WEST SUSSEX COUNTY COUNCIL CONSULTATION

TO:	Arun District Council FAO: Emma Sheppard
FROM:	WSCC – Highways Authority
DATE:	10 th April 2025
LOCATION:	Land at Oldlands Farm Newlands Road Bognor Regis PO22 9NN
SUBJECT:	BE/16/25/RES Approval of reserved matters following outline consent BE/150/22/OUT comprising of 3 No. units within Class B2 and/or B8 of the Use Classes Order (including ancillary office provision) with associated enabling works, parking, landscaping and sustainable drainage system with access off Newlands Road. This application is in CIL Zone 4 (Zero Rated) as other development.
DATE OF SITE VISIT:	Site known to officer
RECOMMENDATION:	Advice

SWEPT PATH ANALYSIS OF 16.5M
HGV - INTERNAL LAYOUT - B2

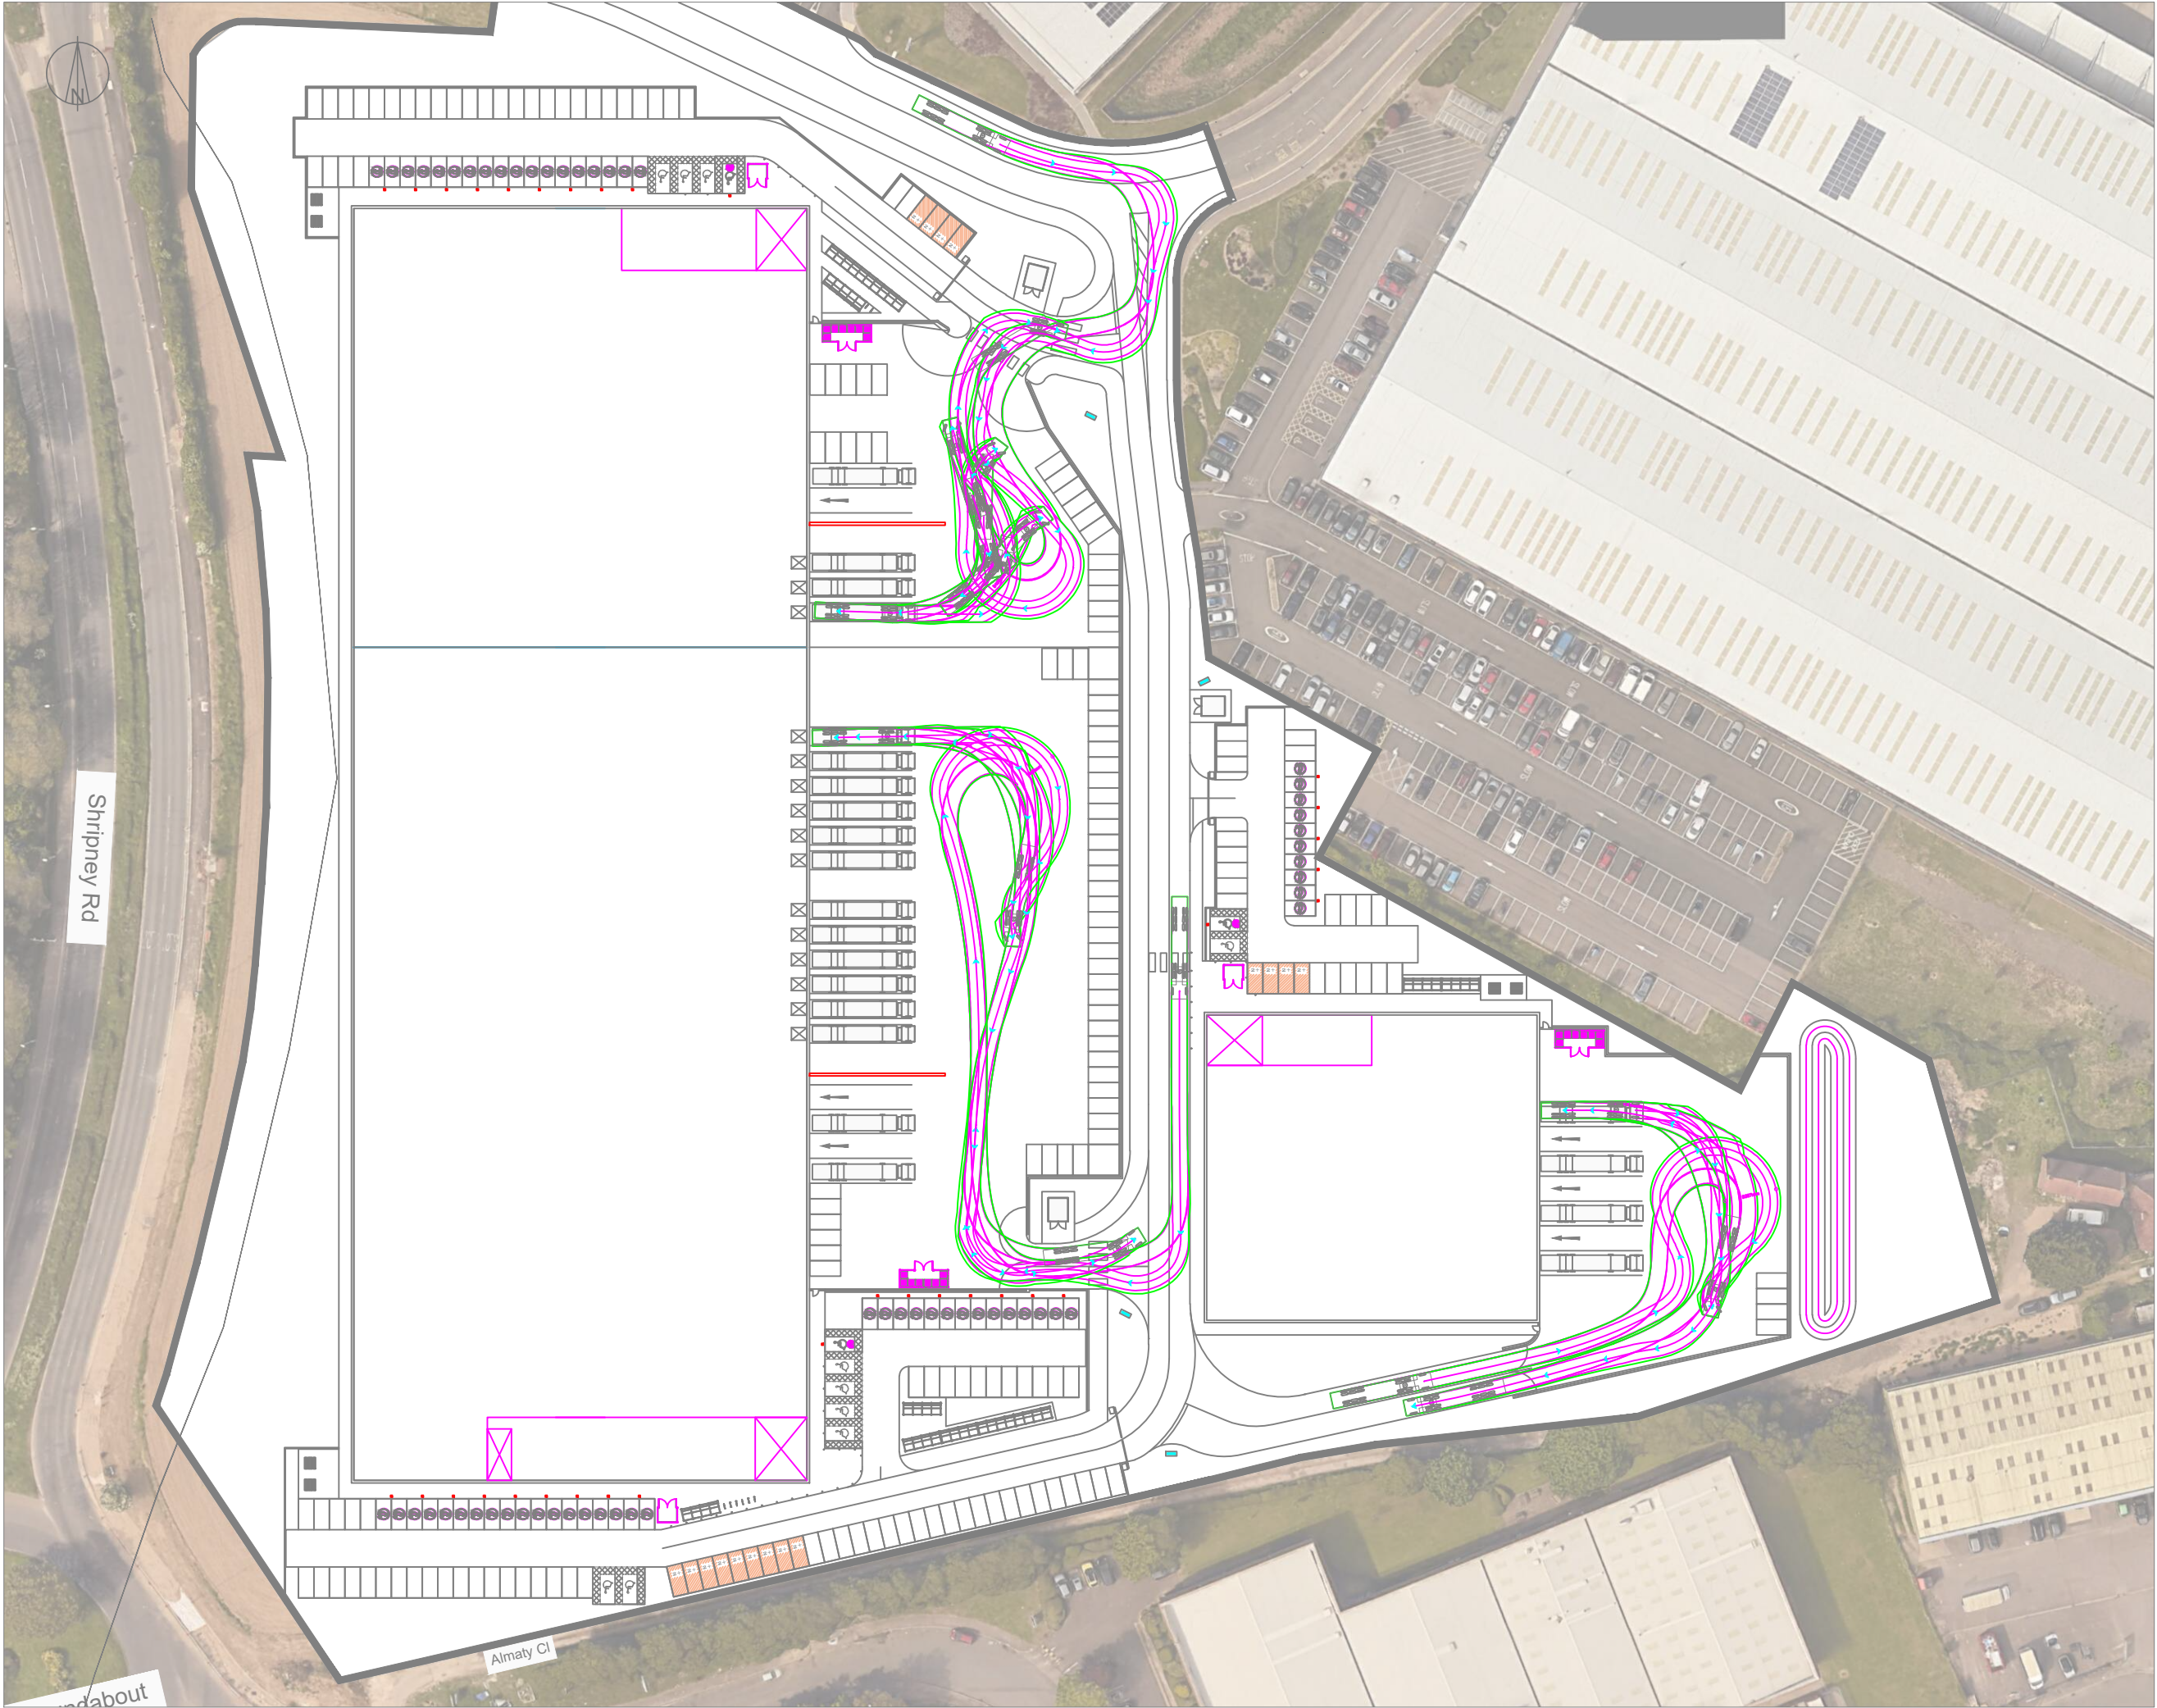
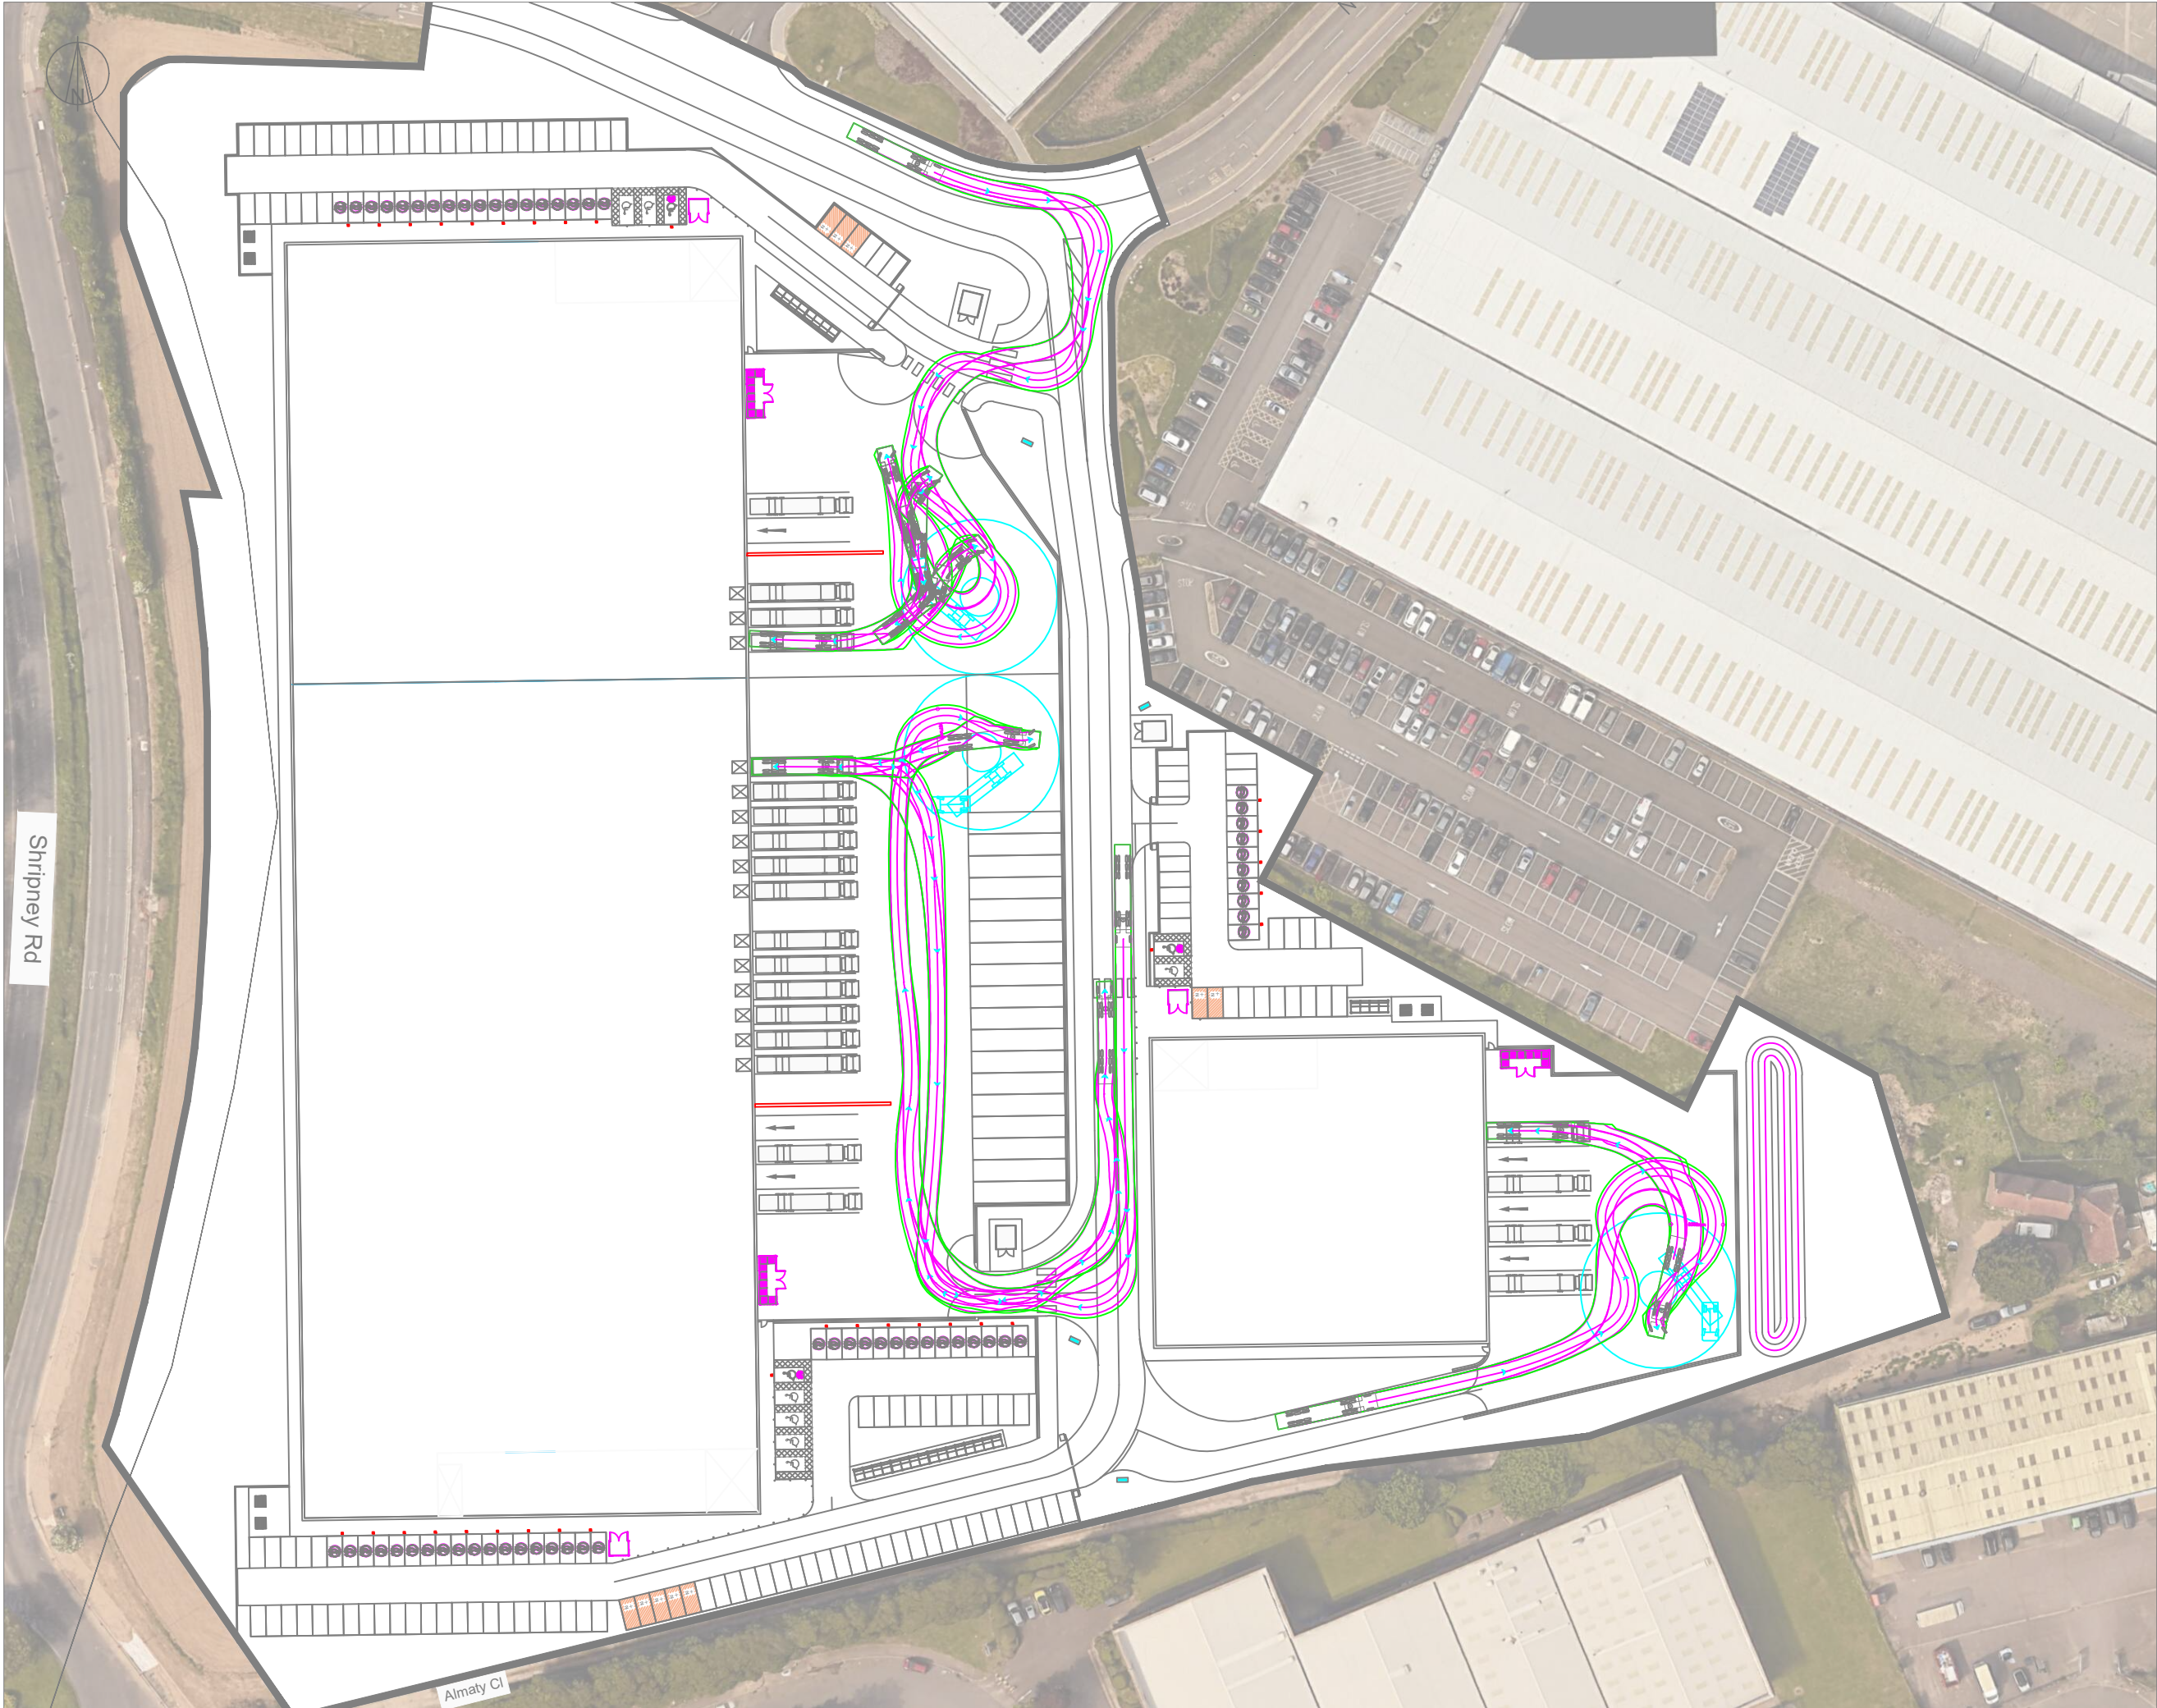
- Swept path diagrams for the site have been shown in Appendix 7 of the TN.
- Whilst a refuse tender has not been tracked within the site, an HGV up to 16.5 metre can negotiate the site area therefore a refuse tender which is typically up to 12 metres in length can be accommodated.

Internal Visibility Splay Plans

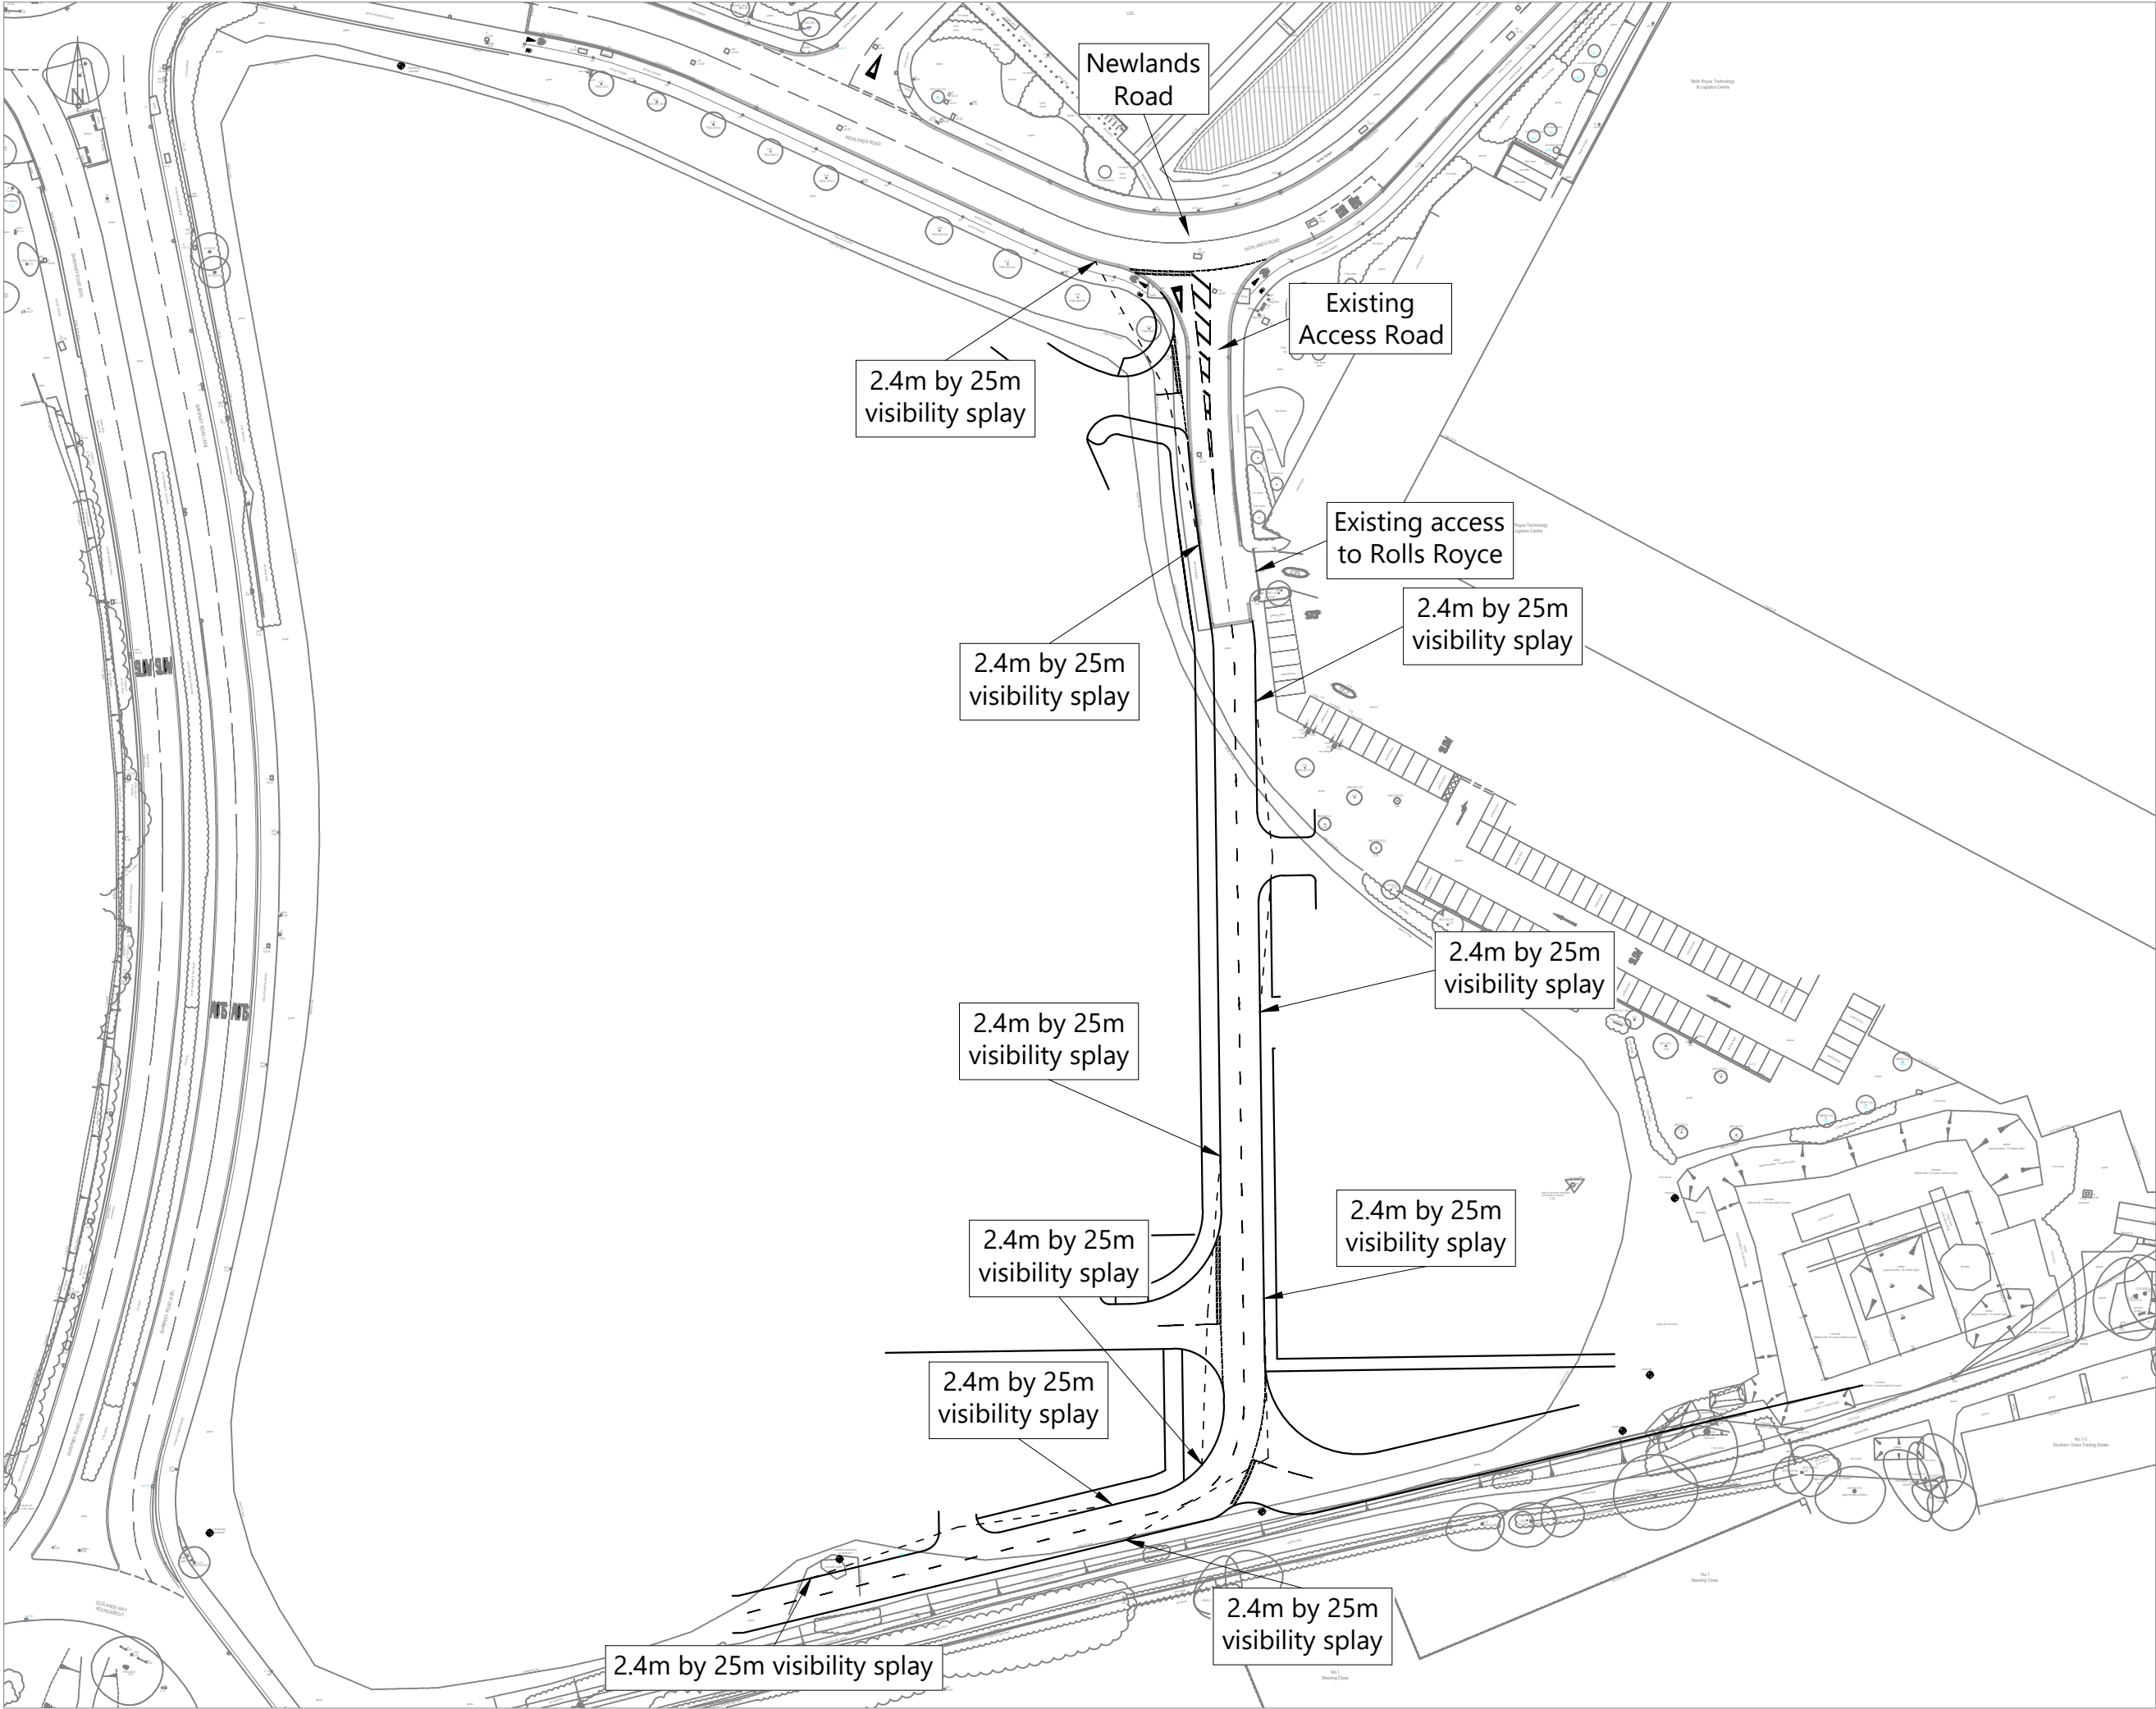
- Each access to the individual units has been shown on drawing HTp/24102/01. Visibility from the existing bellmouth onto Newlands Road is acceptable in both directions. In addition, the TN provides splays of 2.4 by 25 metres from each junction onto the main access spine road. These have been shown on drawing HTp/24102/02 within Appendix 6 of the TN.
